SSD 7228 – SYDNEY ZOO EIS

I am writing to you in reply to your invitation to the EPA to comment on the EIS for the Sydney Zoo project.

ATTACHMENT A
- ENVIRONMENT PROTECTION AUTHORITY COMMENTS -
SYDNEY ZOO

DRAWING STATUS			SHEET SIZE	
E.I.S. EXHIBITION			A1	
DRAFTSMAN J.Fraser	DESIGNER T.Walton	PROJ MANAGER T.Walton	SCALE 1:1000	
PROJECT REF No. 12082		DRAWING No. DA02		REVISION B

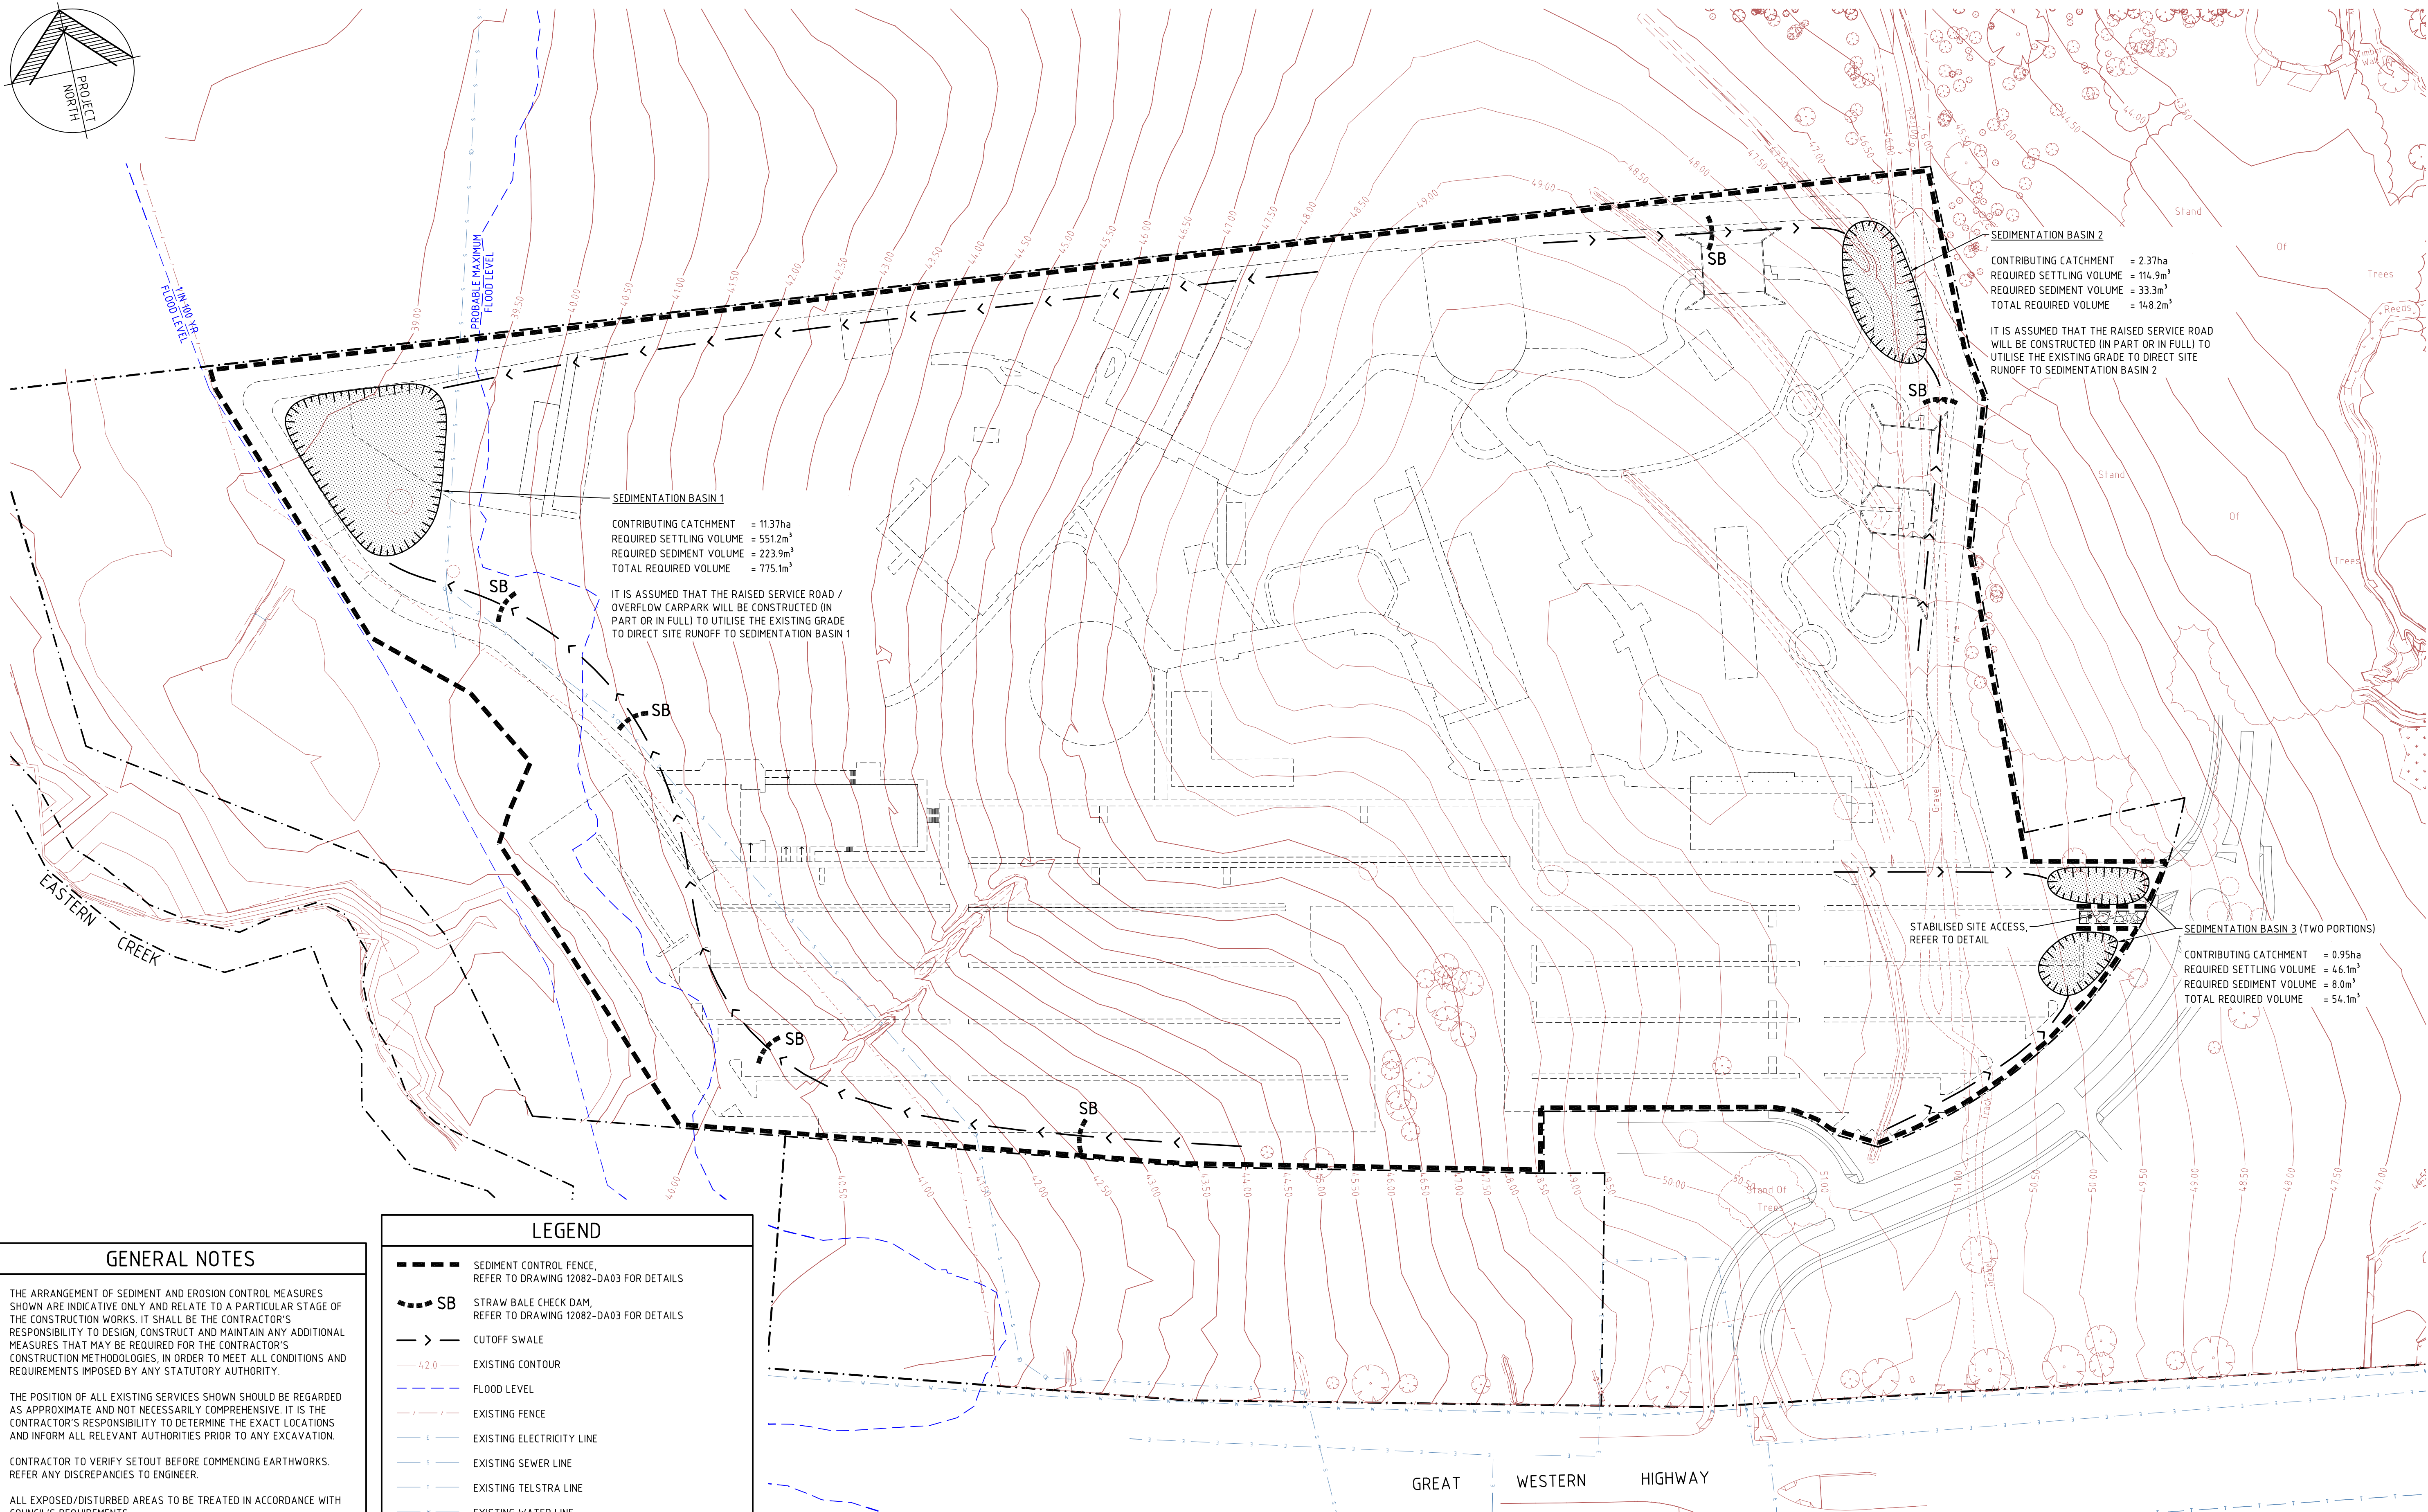
The EPA notes the proximity of Eastern Creek immediately west of the development site. And, considers that erosion and sediment controls should be designed and implemented to prevent pollution of the Creek during site preparation, bulk earthworks, construction and construction-related activities.

- (a) not commencing earthmoving or vegetation removal until appropriate erosion and sediment controls are in place, and
- (b) daily inspection of erosion and sediment controls which is fundamental to ensuring timely maintenance and repair of those controls.

The proponent be required to plan and implement erosion and sediment control measures consistent with the practices and principles in –

- Managing Urban Stormwater Soils and Construction, Volume 1, 4th Edition, 2004, and
- Managing Urban Stormwater Soils and Construction Volume 2A Installation of Services.

TYPICAL WET MOAT - TIGERS

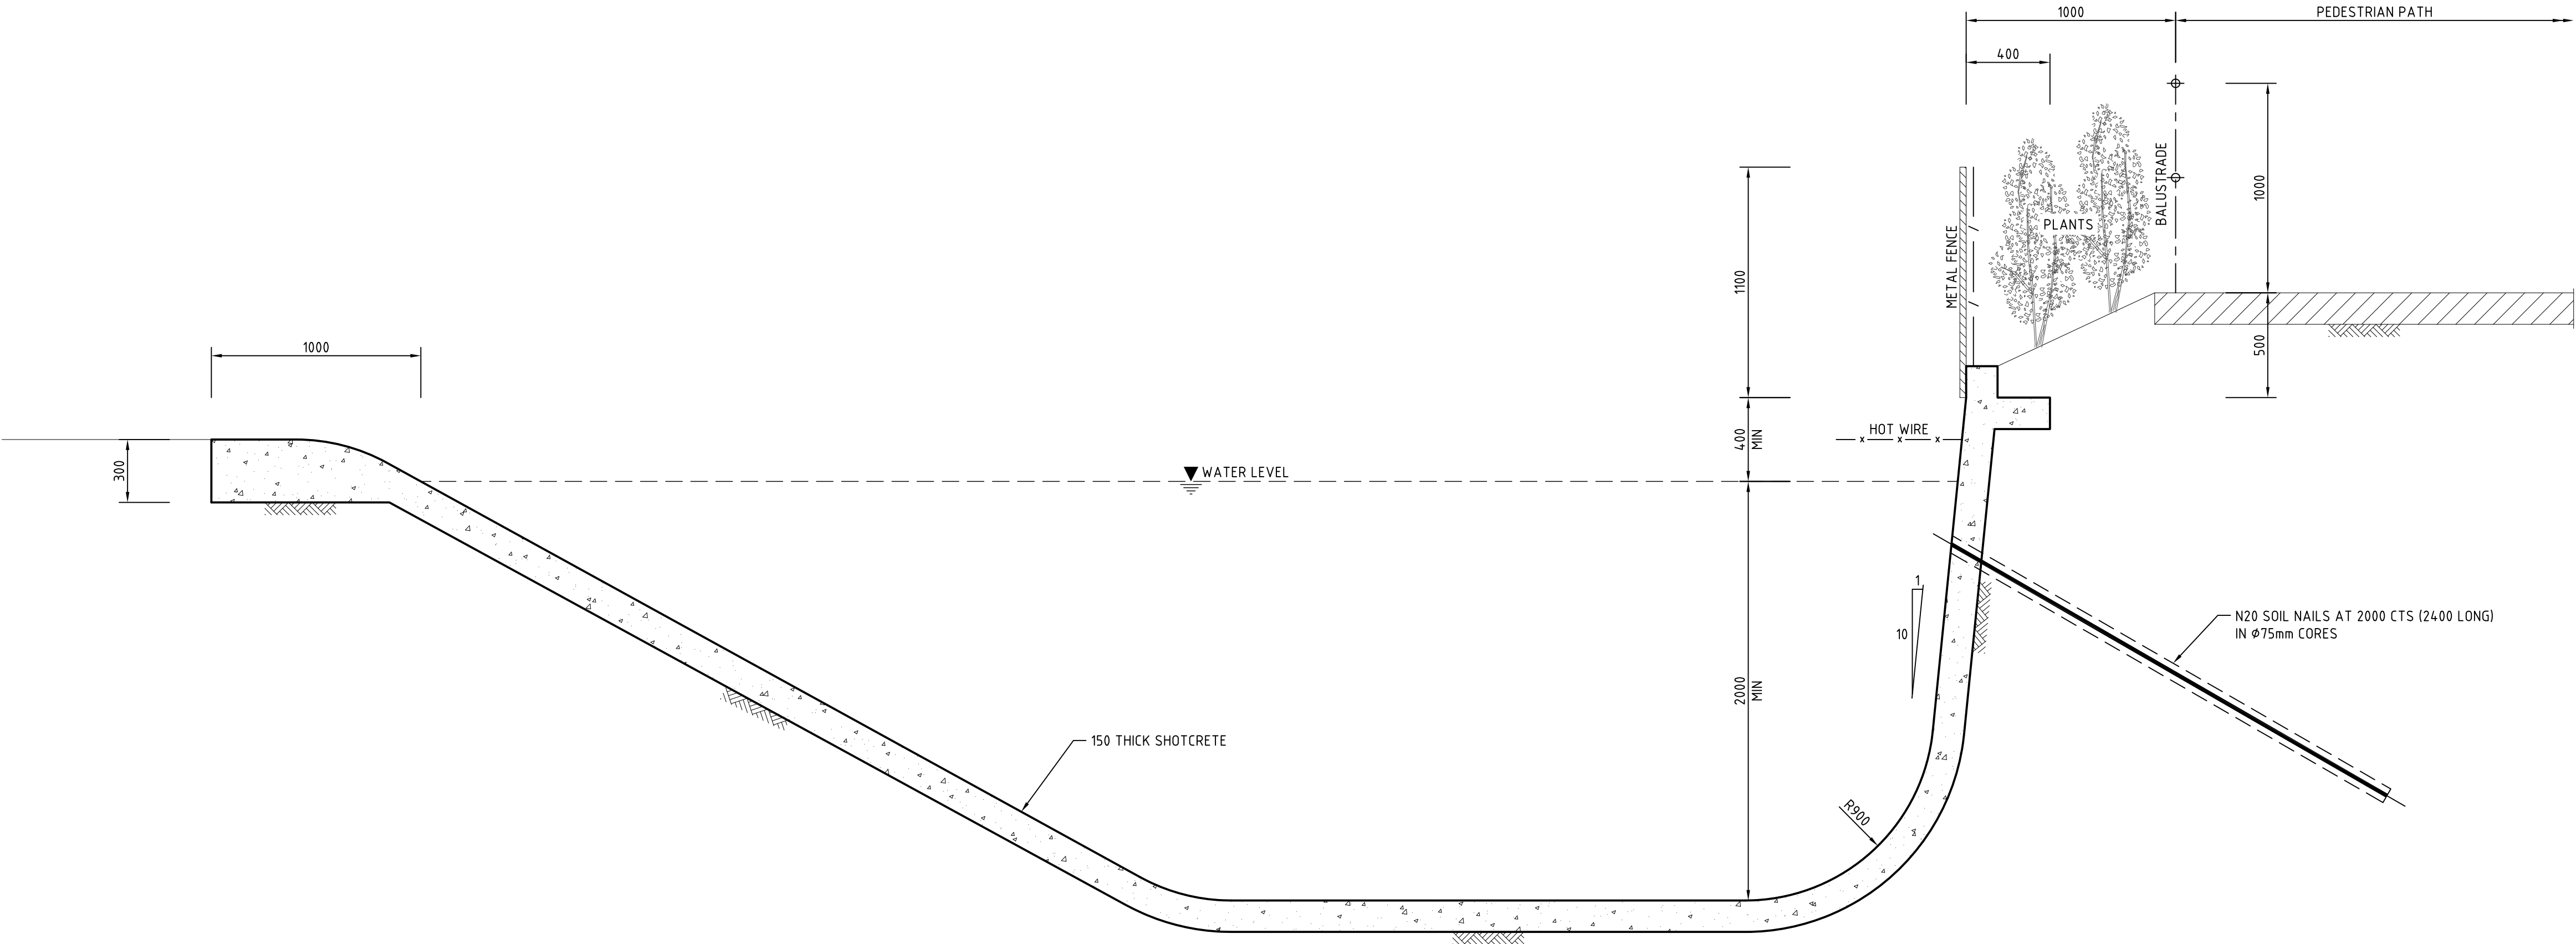
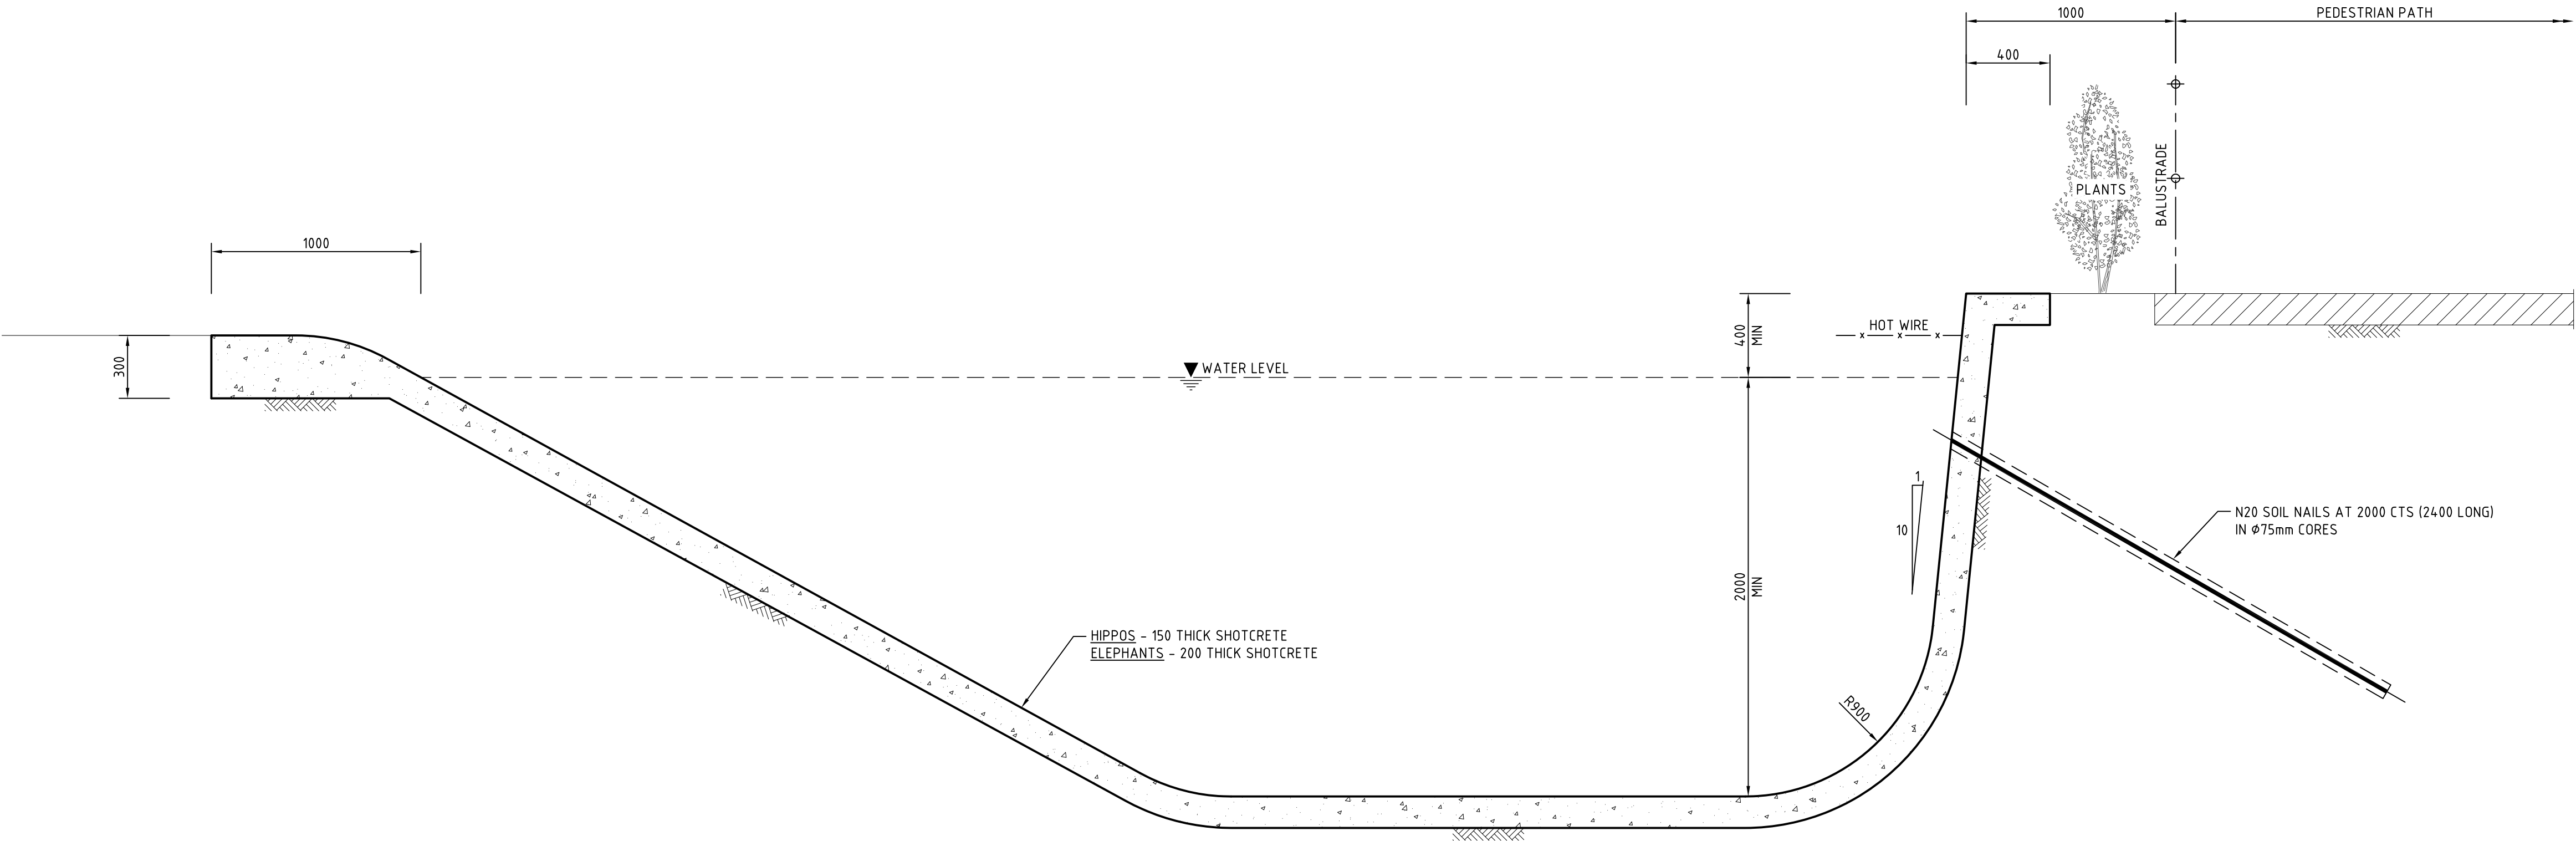
The EPA anticipates that run-off from animal enclosures will contain higher concentrations of nutrients, suspended solids, organic matter and pathogens relative to urban stormwater and thus water sensitive urban design devices may not be suitable to treat that effluent. Similarly, the EPA anticipates that wastewater from the hippopotamus pool, aquaria and wet moats may warrant additional or alternative treatment.

- (a) suitability of proposed water treatment measures, including those proposed for the treatment of –
 - (i) run-off from animal enclosures, and
 - (ii) discharges from the hippopotamus pool, aquaria and wet moats;
- (b) expected water quality from different sources on the site; and
- (c) design storm sizing for each storage proposed to discharge to waters.
